From: [REDACTED]
Sent: 31 October 2022 08:35
To: Planning
Subject: Planning Application No 3/2022/0923 - 3 Knowsley Road West, Clayton-le-Dale

Subject: Planning Application No 3/2022/0923 - 3 Knowsley Road West, Clayton-le-Dale ("the Property")

Application 3/2022/0923

Development address: 3, Knowsley Road West, Wilpshire BB1 9PW

Side Elevation

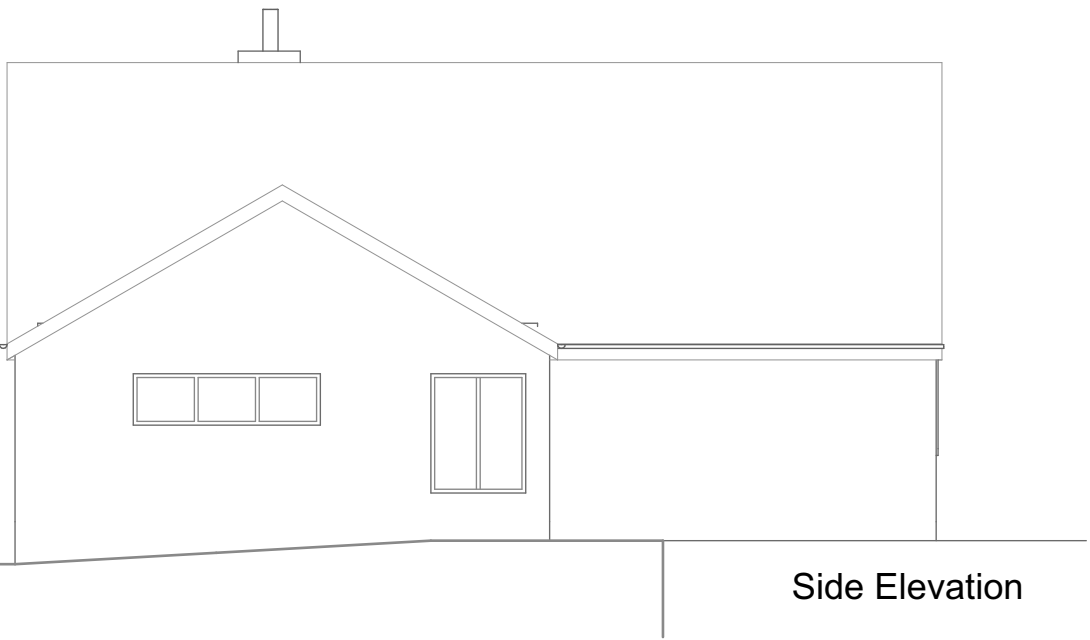
The plan of the proposed raised deck side view is not comprehensive enough and does not show the same side elevation as the existing elevations do, in relation to:

- The exact location of where the fence and retaining wall will be situated as measurements are not provided
- The side view of regraded slope to lawn, how high the current land boundary level will be raised to allow the regrading of the slope, and how close this is to the existing boundary, and its measurements.
- The new 1500mm fence; will this then go on top of the new retaining base wall? If so, how high will the new retaining base wall be?

The estimated height of the existing patio level above the boundary level is approx. 1000 mm. A further increase of this height of 600mm for proposed decking would potentially make a 2000mm boundary fence become, in effect, 400mm high, reducing it to knee height resulting in significant privacy issues by being overlooked.

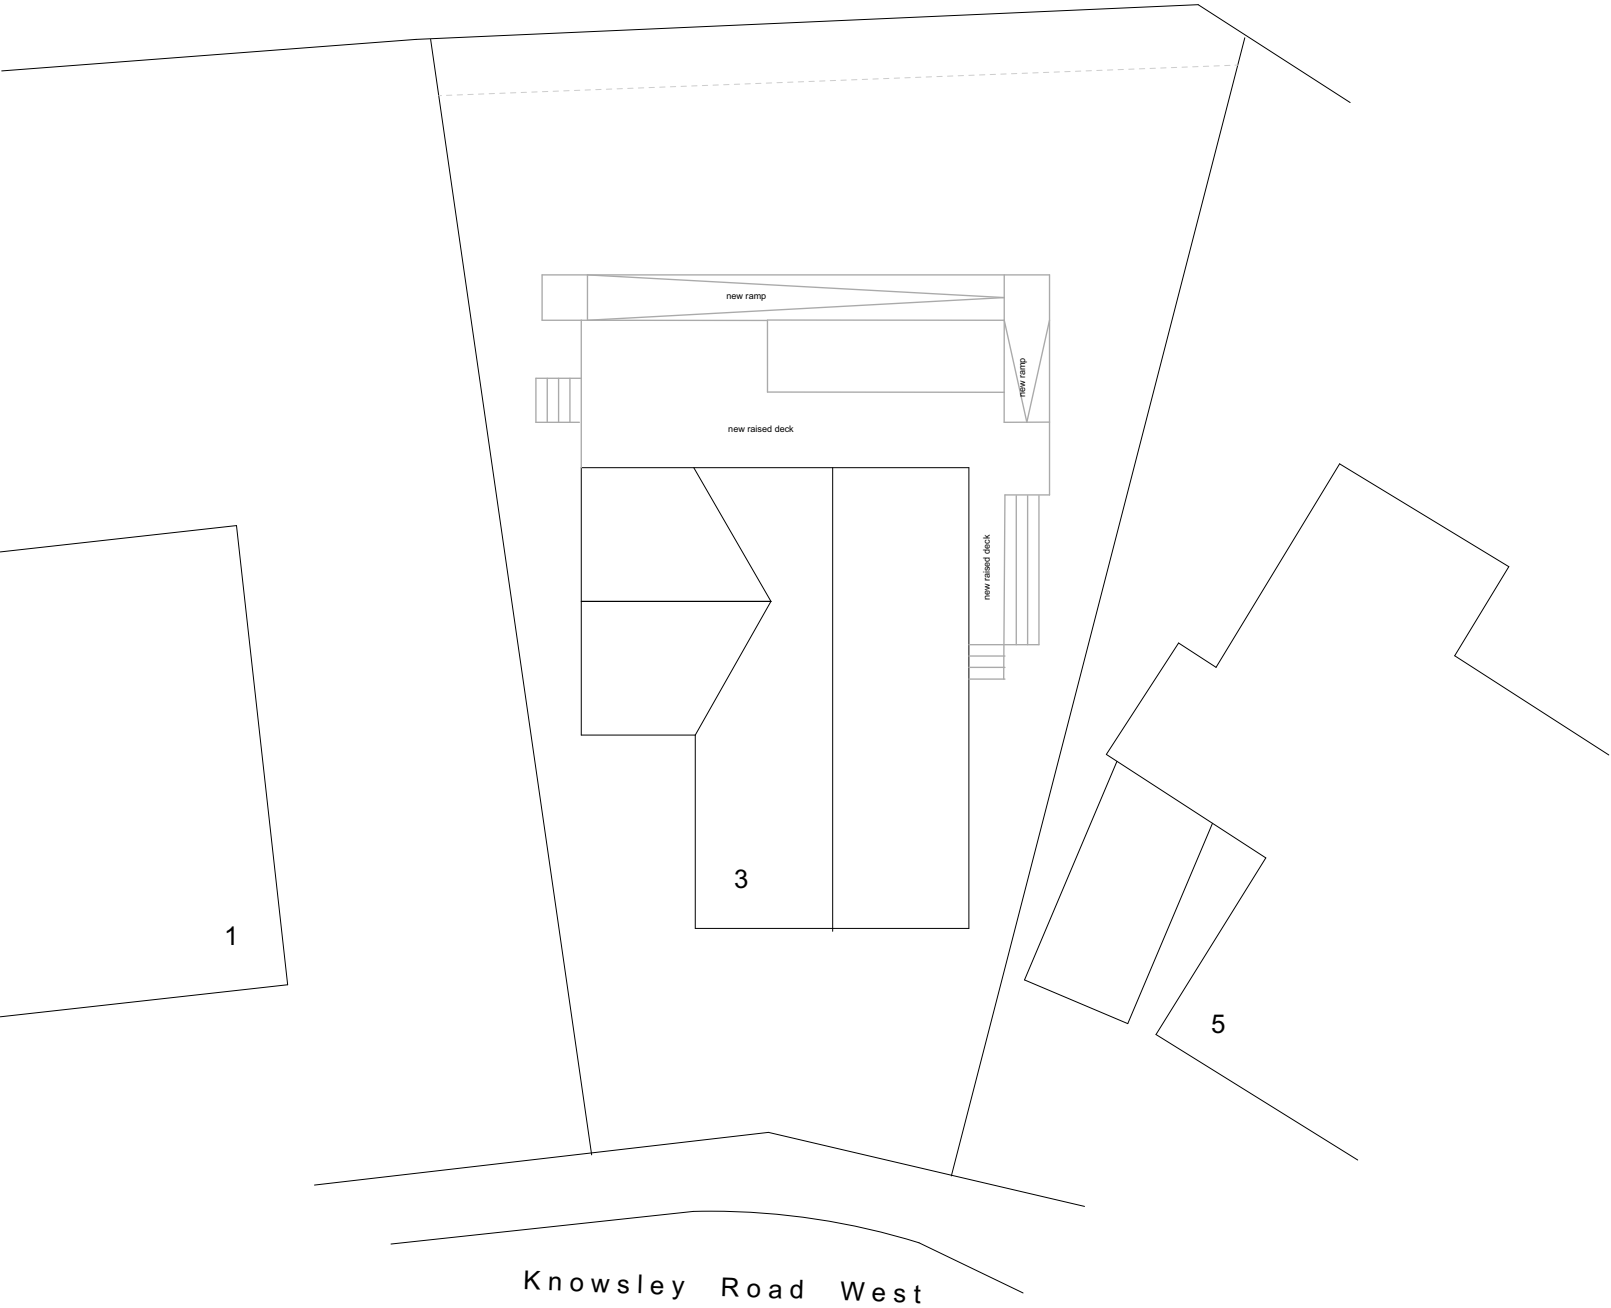
I have looked at the plans available online and it appears that the proposal is that a large raised decking area be constructed to the rear of the Property. In addition there appears to be a ramp created in the rear garden at the side of the Property [REDACTED]. It is my understanding that planning permission is needed because the intention of the applicant is to raise the level of the decking 0.6 m above the current ground level across the whole of the decking area. It is not clear from the application why the existing ground level is to be raised by 60 cms. I believe that this will be unduly intrusive and impact [REDACTED]. The planning application submitted makes reference to erecting a fence where the Property adjoins [REDACTED] Knowsley Road but there is no indication that the [REDACTED] will be increased in height which would help to reduce any [REDACTED].

1. The proposal would have an adverse environmental impact in general terms as an area including shrubs and lawn will be removed and replaced with a decking area (an impermeable surface) covering a significant portion of the external rear garden at the Property. I note that the applicant states that no trees will need to be removed to create the large decking area (an area. Whilst this might the case as of mid-October 2022 [REDACTED] I can confirm that the current owners of the Property have removed trees before submitting the planning application referenced above.
